**KIRKLEES METROPOLITAN COUNCIL
TOWN AND COUNTRY PLANNING ACT 1990
HIGHWAYS DEVELOPMENT CONTROL KP20H**

PLANNING REF 2016/62/92812/W0/FT
CATEGORY Small Major

PROPOSAL DEMOLITION OF INDUSTRIAL
BUILDING AND ERECTION OF 17
NO. APARTMENTS WITH INTEGRAL
GARAGES AND ASSOCIATED
PARKING

LOCATION VICTORIA WORKS,
FISHER GREEN,
HONLEY,
HOLMFIRTH,
HD9 6DP

Lower Ground Floor

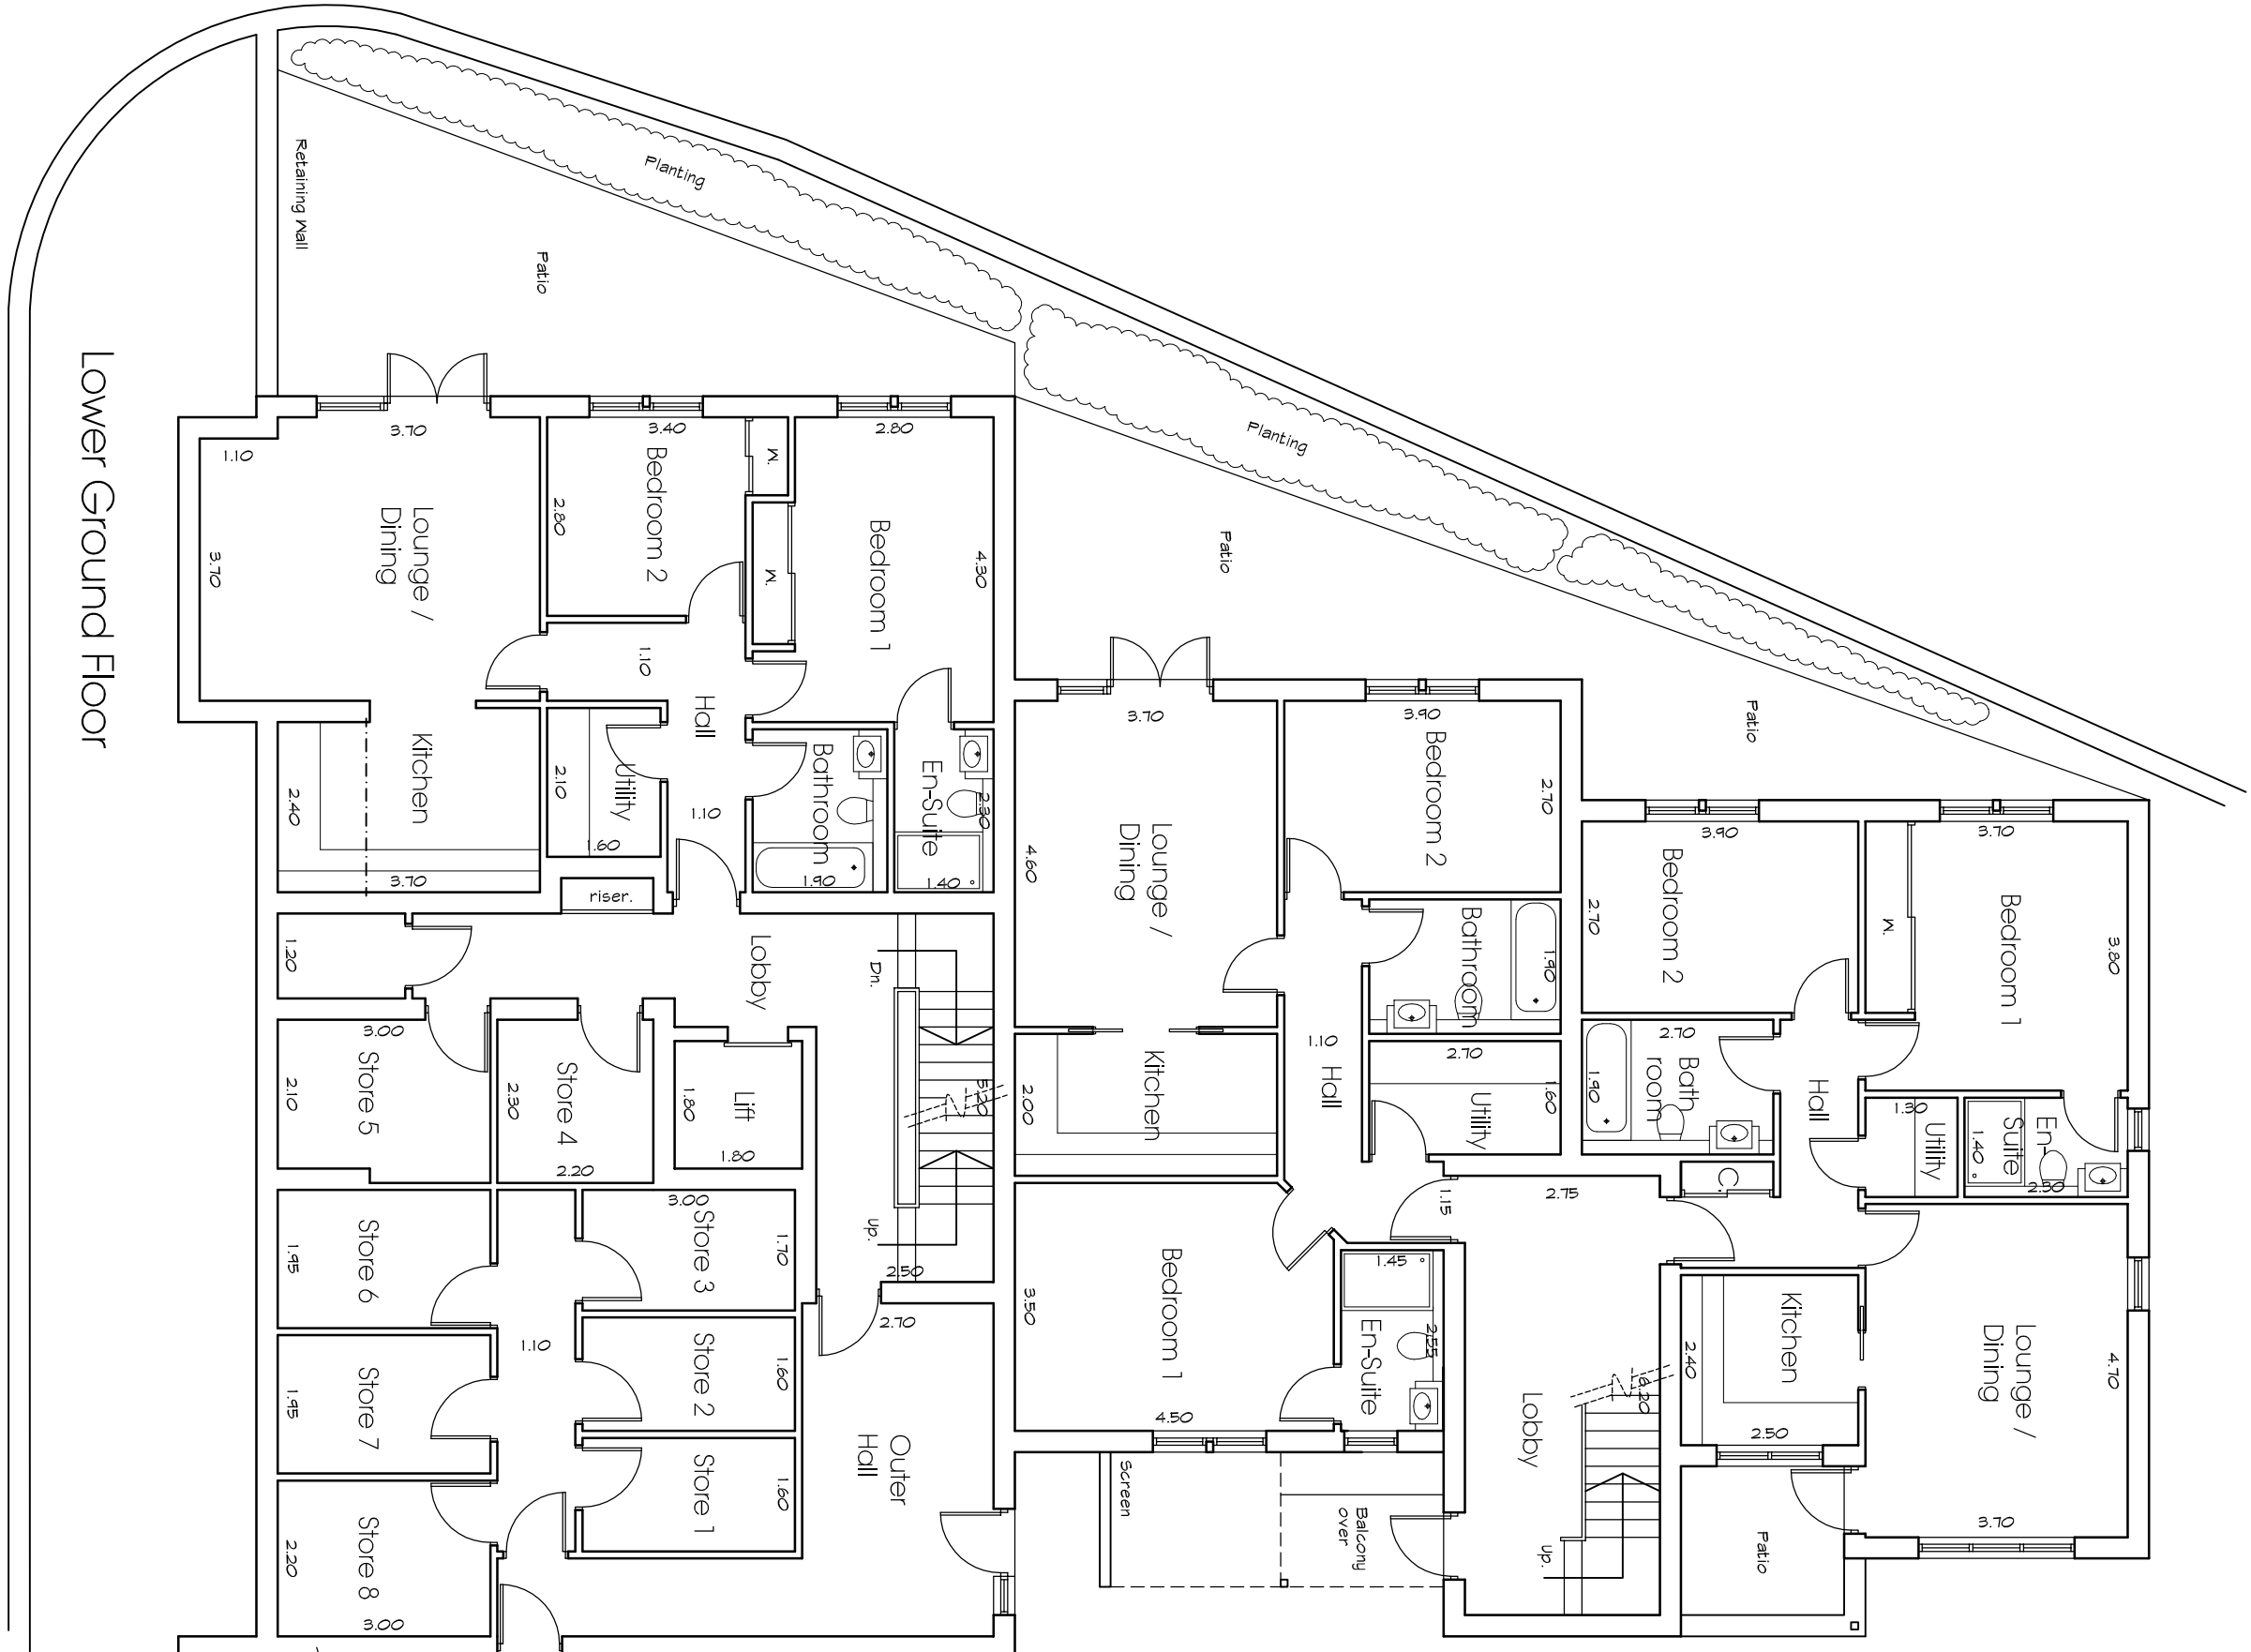
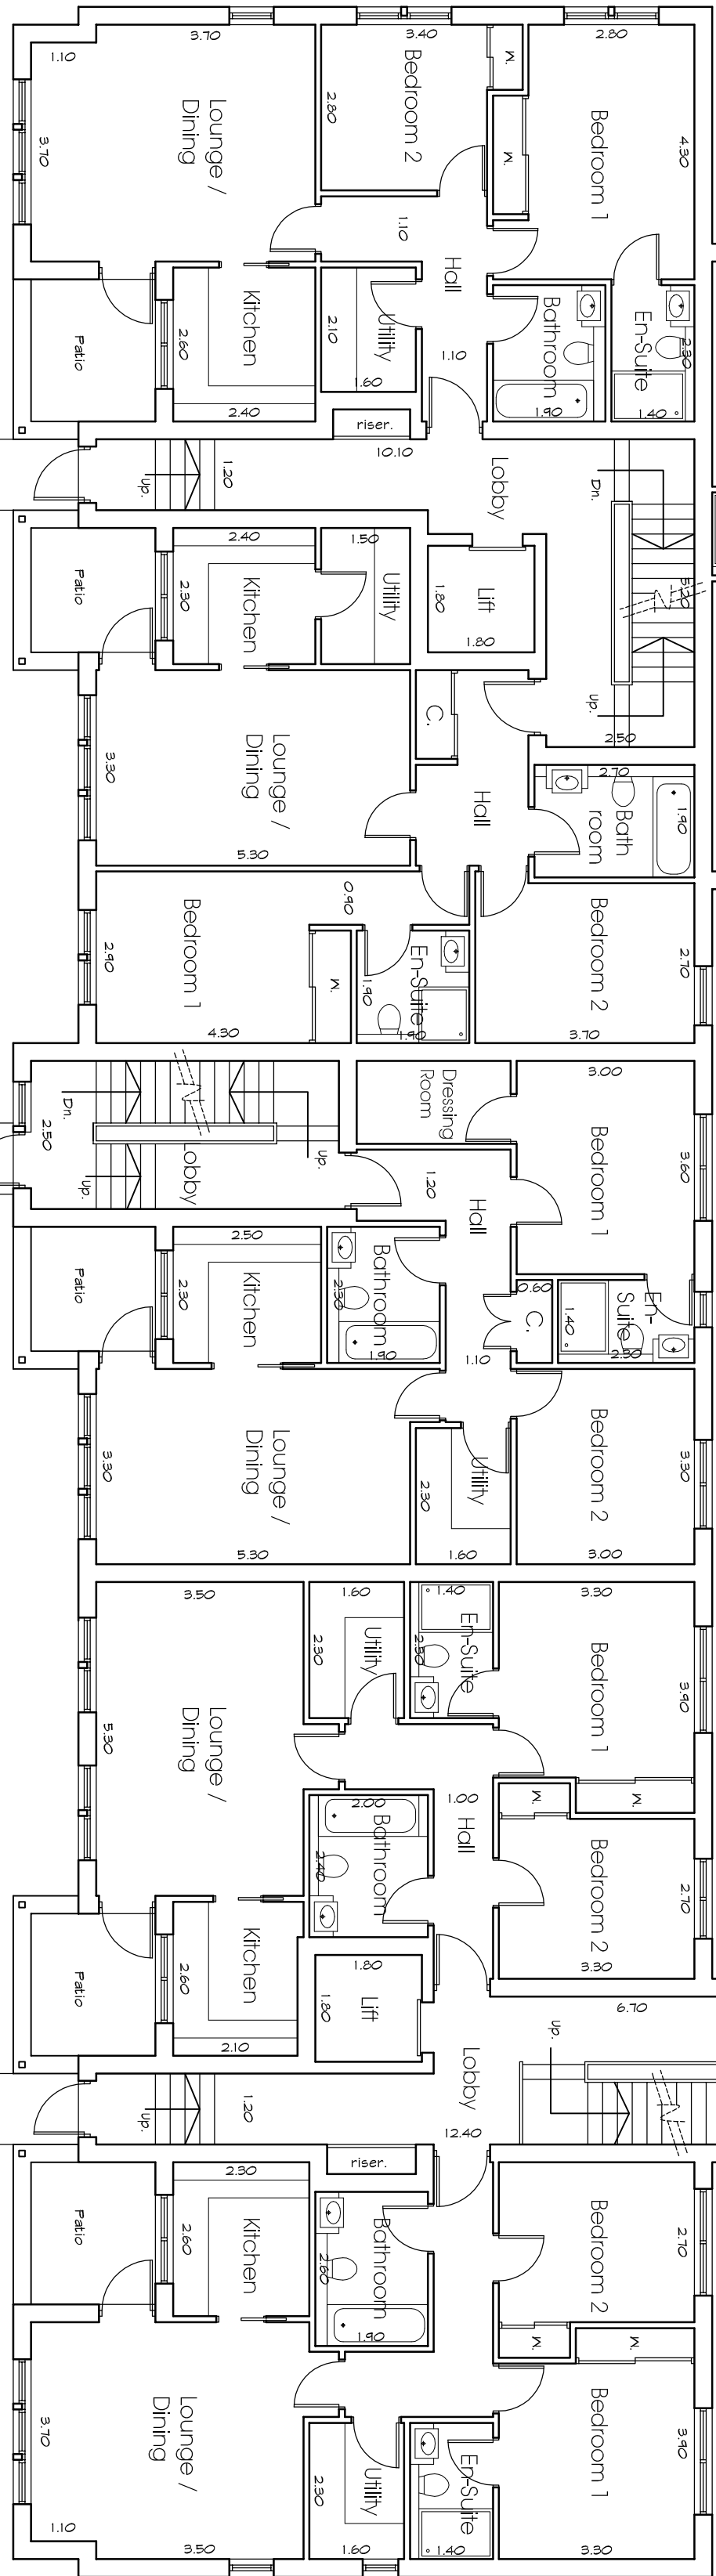
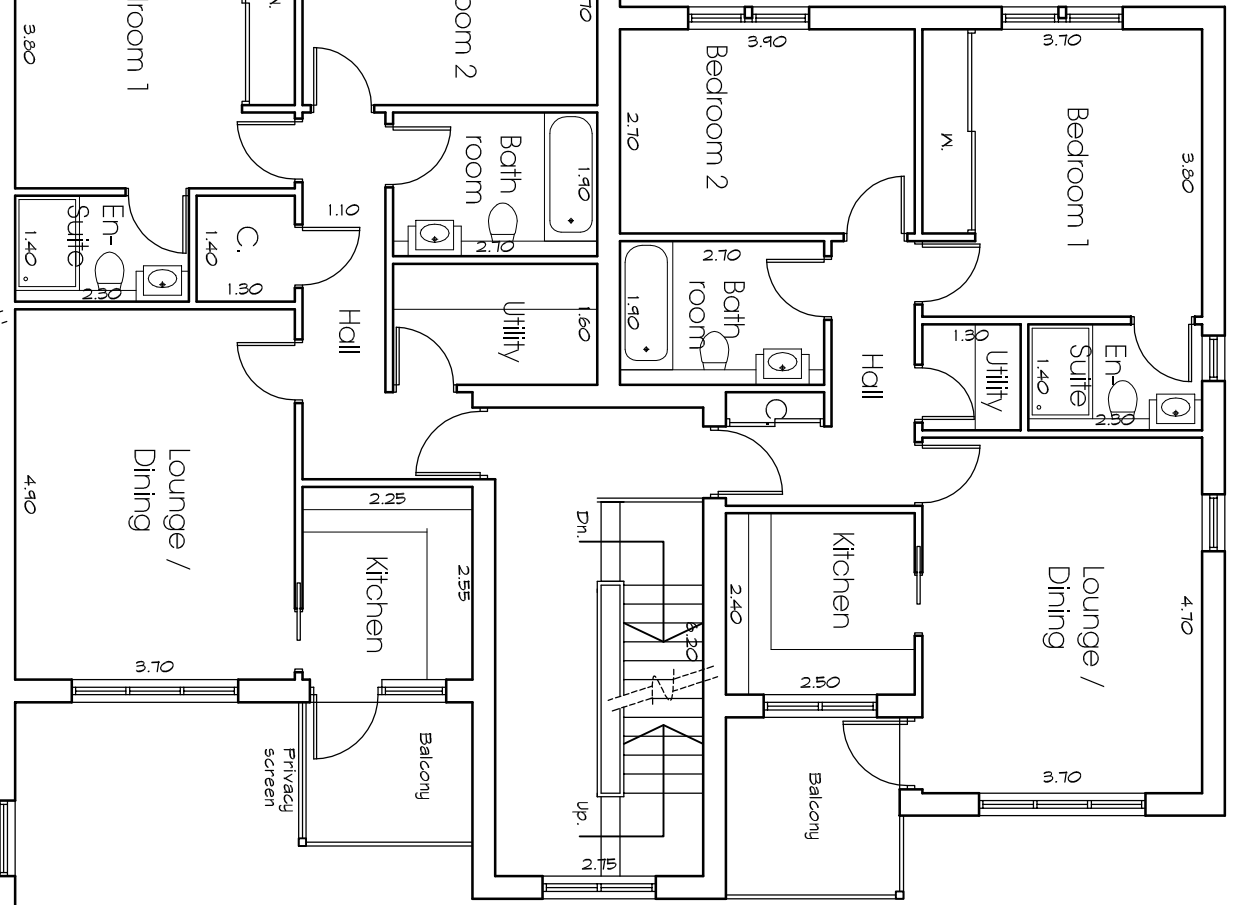
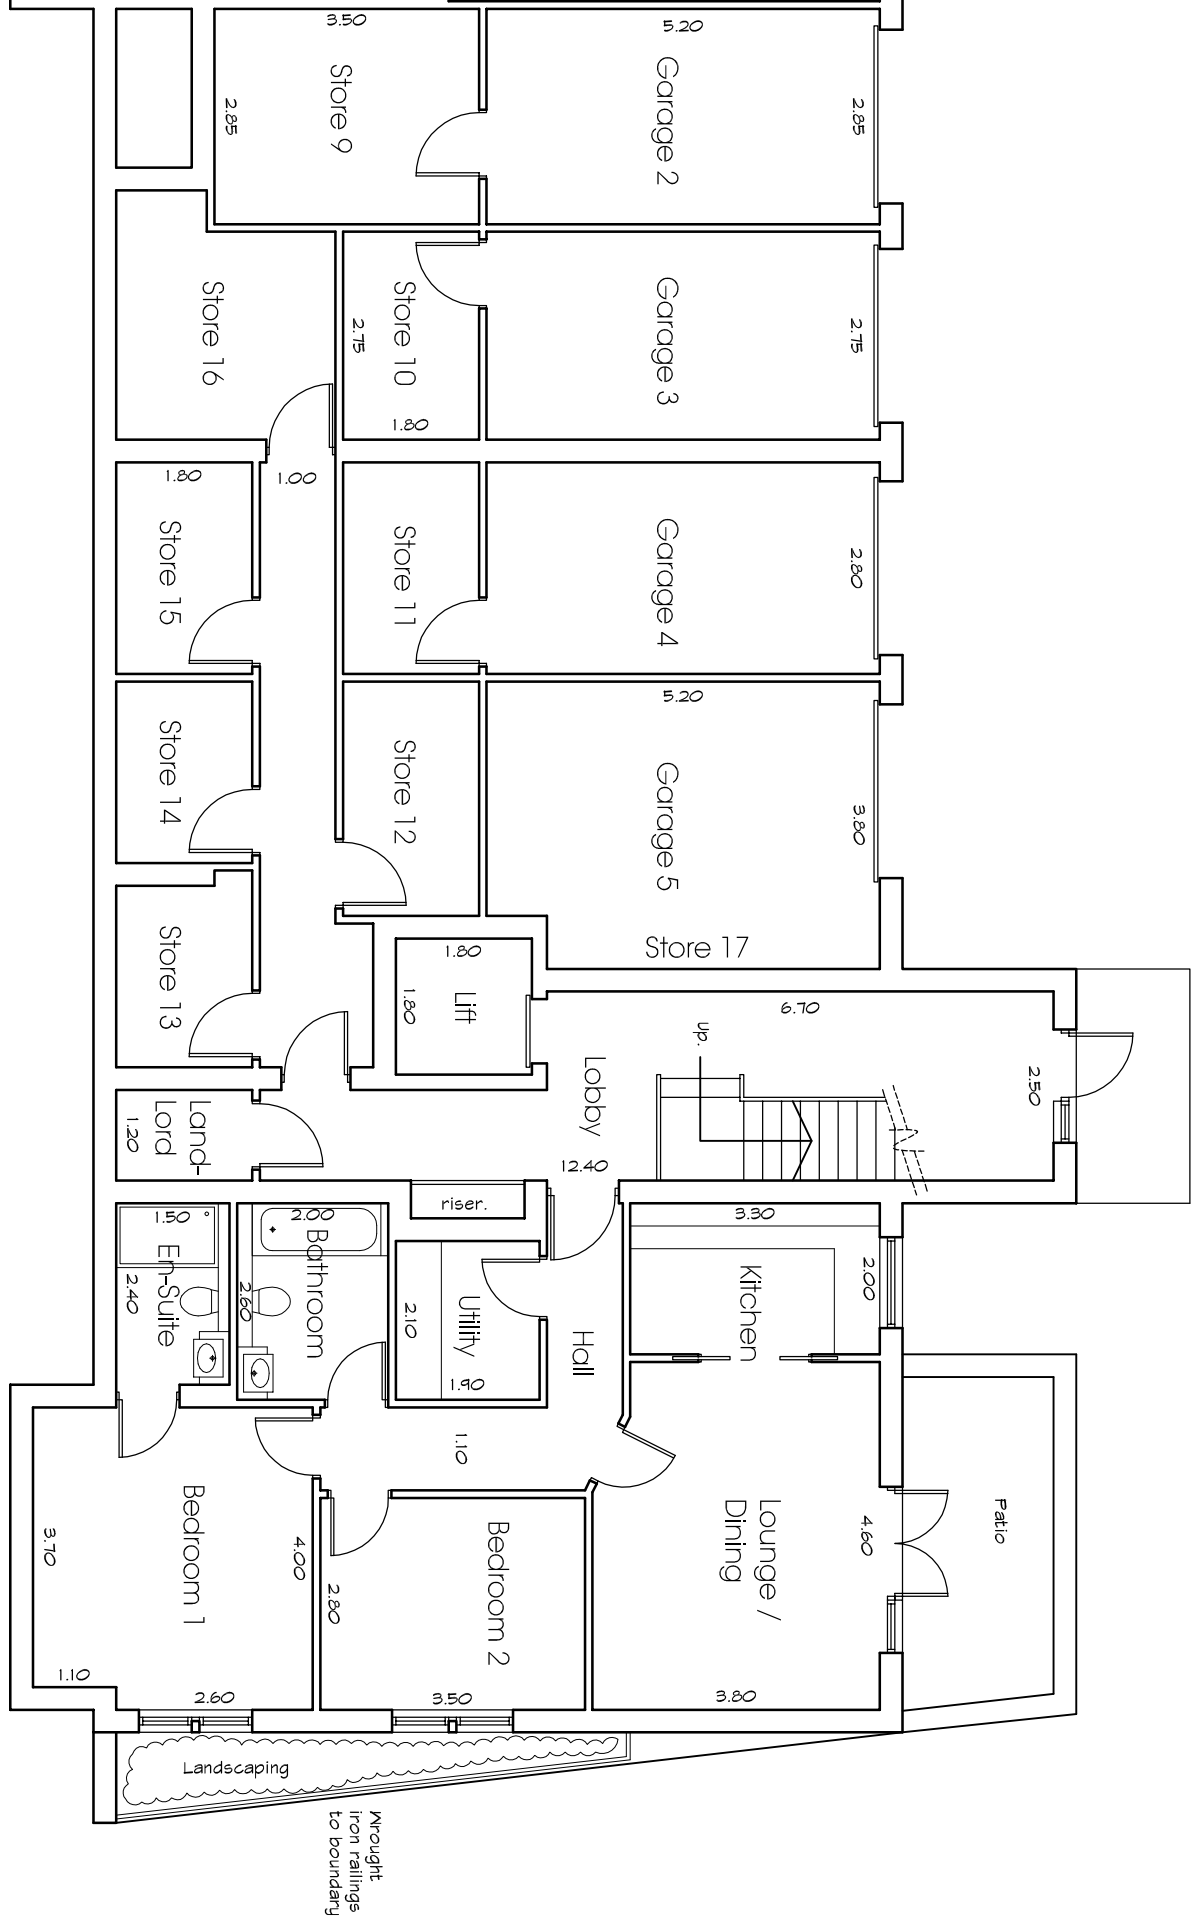
Waste collection/ bin collection points are still a concern. Residents should not be required to carry waste more than 30m to the storage point. Access via the proposed gate leading to Meltham Road appears too narrow. Access to the external storage is via land outside the red line boundary.

Details of the proposed access from inside the site to the waste storage point needs to be provided.
